From: [Downes, Scott G \(DFW\)](#)
To: [Dusty Pilkington](#)
Cc: [Renfrow, Brent D \(DFW\)](#)
Subject: RE: VA-16-00001 Mostofi-WDFW Comments
Date: Monday, September 12, 2016 10:58:00 AM
Attachments: [WDFW comments on Mostofi Building Setback Variance.pdf](#)

From: Dusty Pilkington [mailto:dusty.pilkington@co.kittitas.wa.us]
Sent: Tuesday, August 30, 2016 10:14 AM
To: Josh Hink; Julie Kjorsvik; Lisa Iammarino; Myers, Holly (DOHi); Lisa Lawrence; Kelly Bacon; Renfrow, Brent D (DFW); Downes, Scott G (DFW); Nelson, Jennifer L (DFW); Michael Flory; Lou Whitford; Amber Green; Mau, Russell E (DOH); Josh Hink; montgomeryr@cersd.org; wargog@cersd.org; Steph Mifflin; Lucas Huck; Kim Dawson; Lisa Lawrence; SEPA (DAHP); HAZLETT, LINDA (DNR); PRESTON, CINDY (DNR); DNR RE AQ LEASING RIVERS; brooksideconsulting@gmail.com; Stoner, Jana; Joanna Markell; Clear, Gwen (ECY); jorgenja@cwu.edu
Subject: VA-16-00001 Mostofi

VA-16-00001

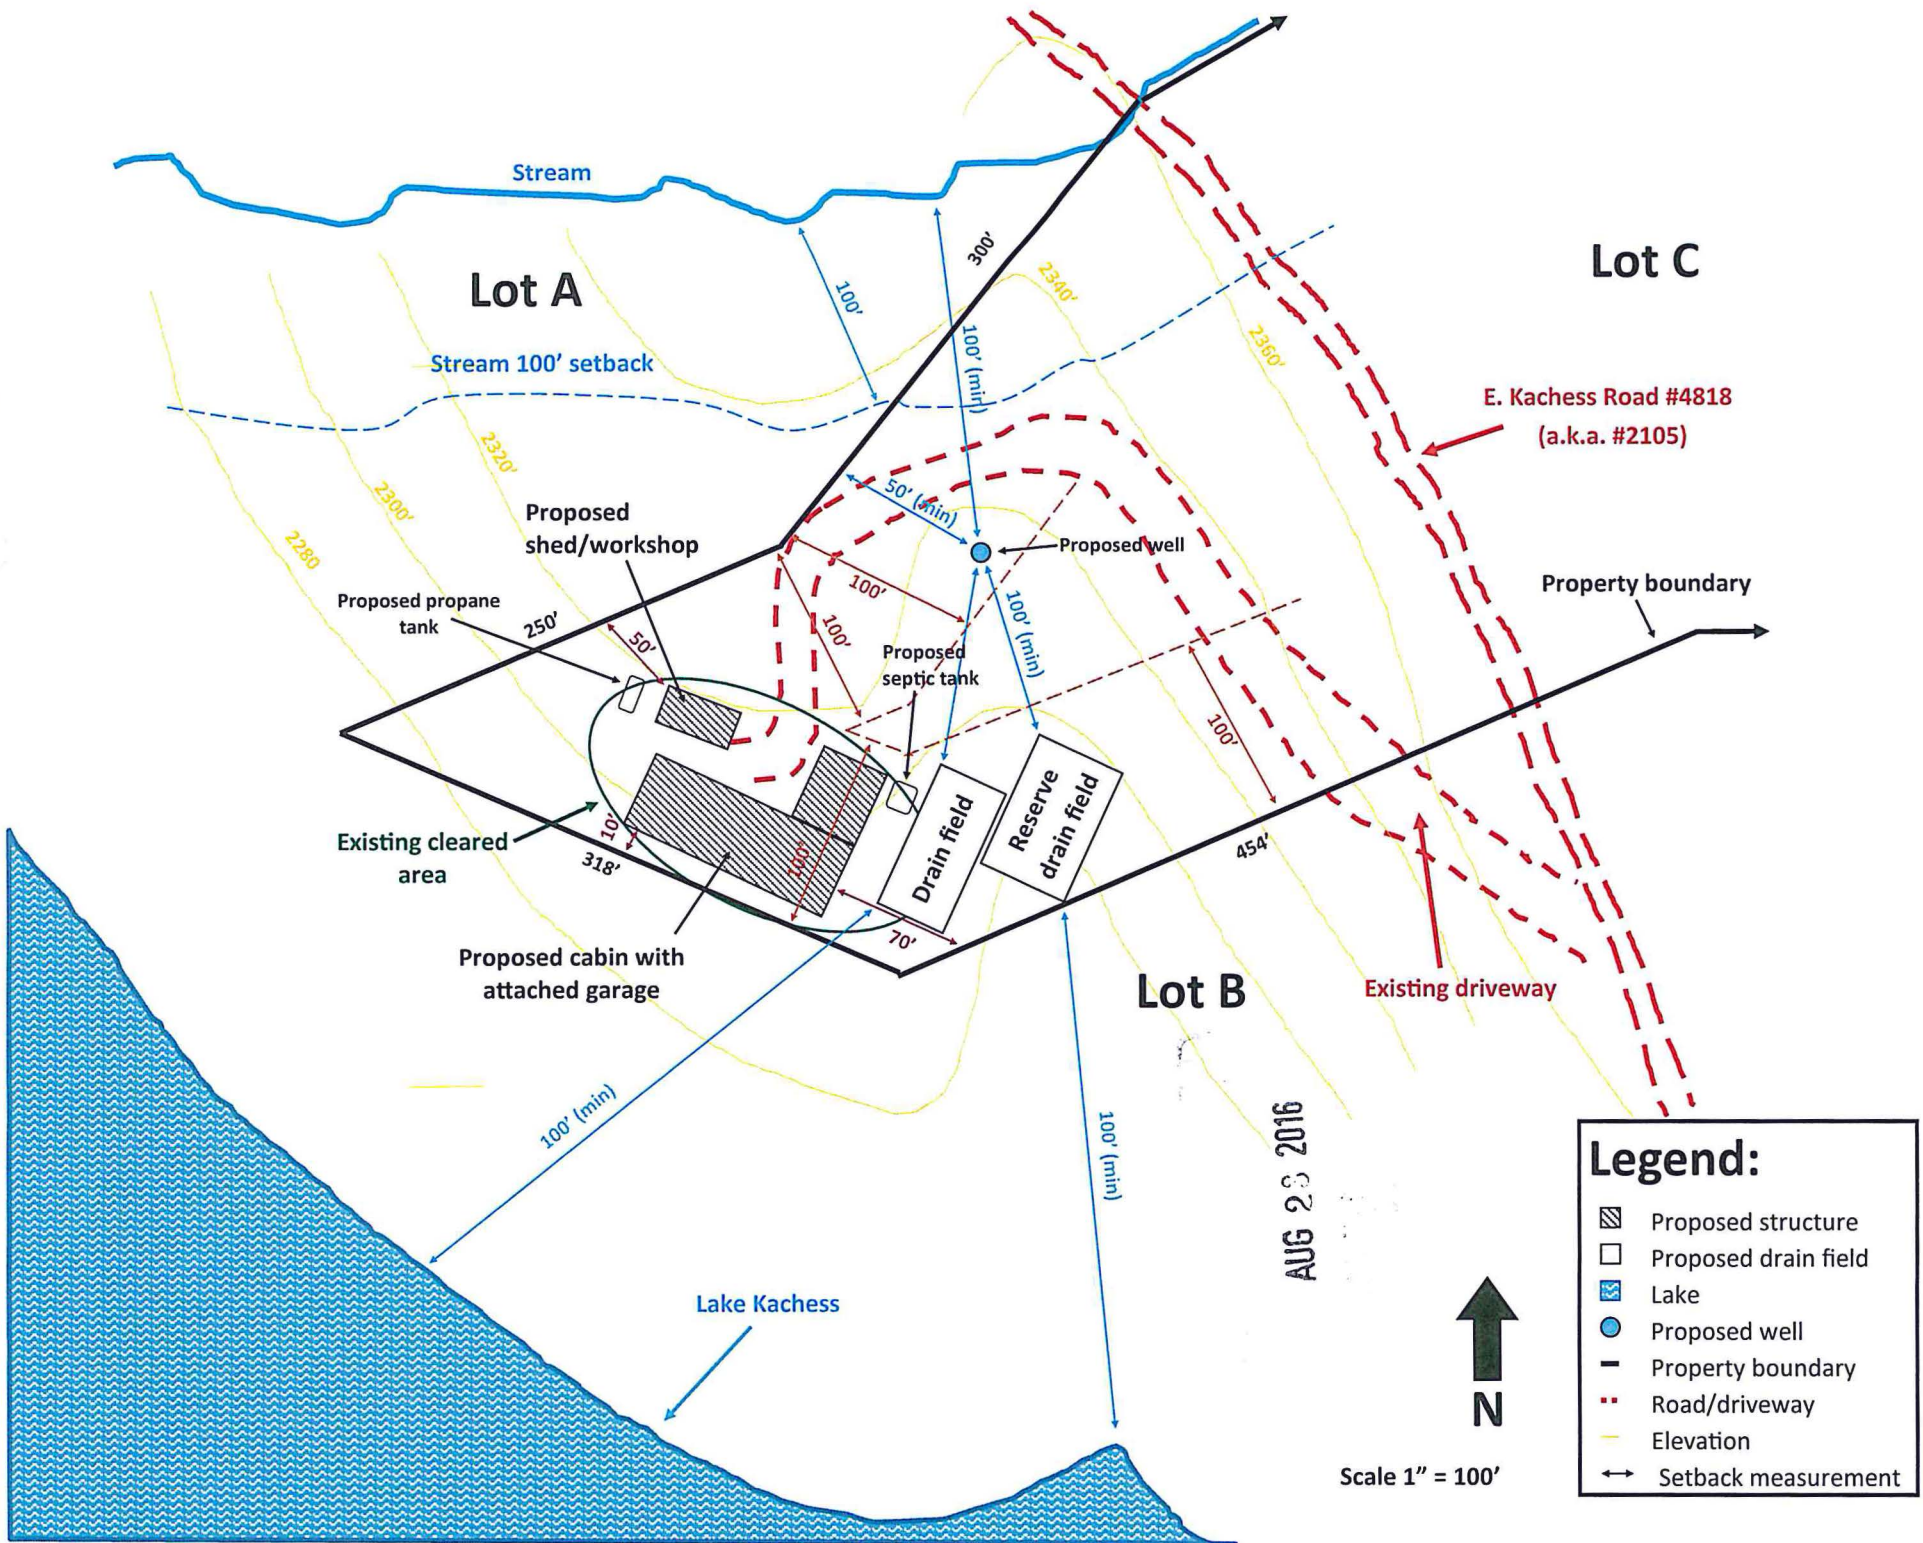
Please see WDFW comments on this variance. WDFW requests that any variance granted to the applicant needs to ensure that the 100 foot minimum buffer for the fish bearing creek and the shoreline is left.
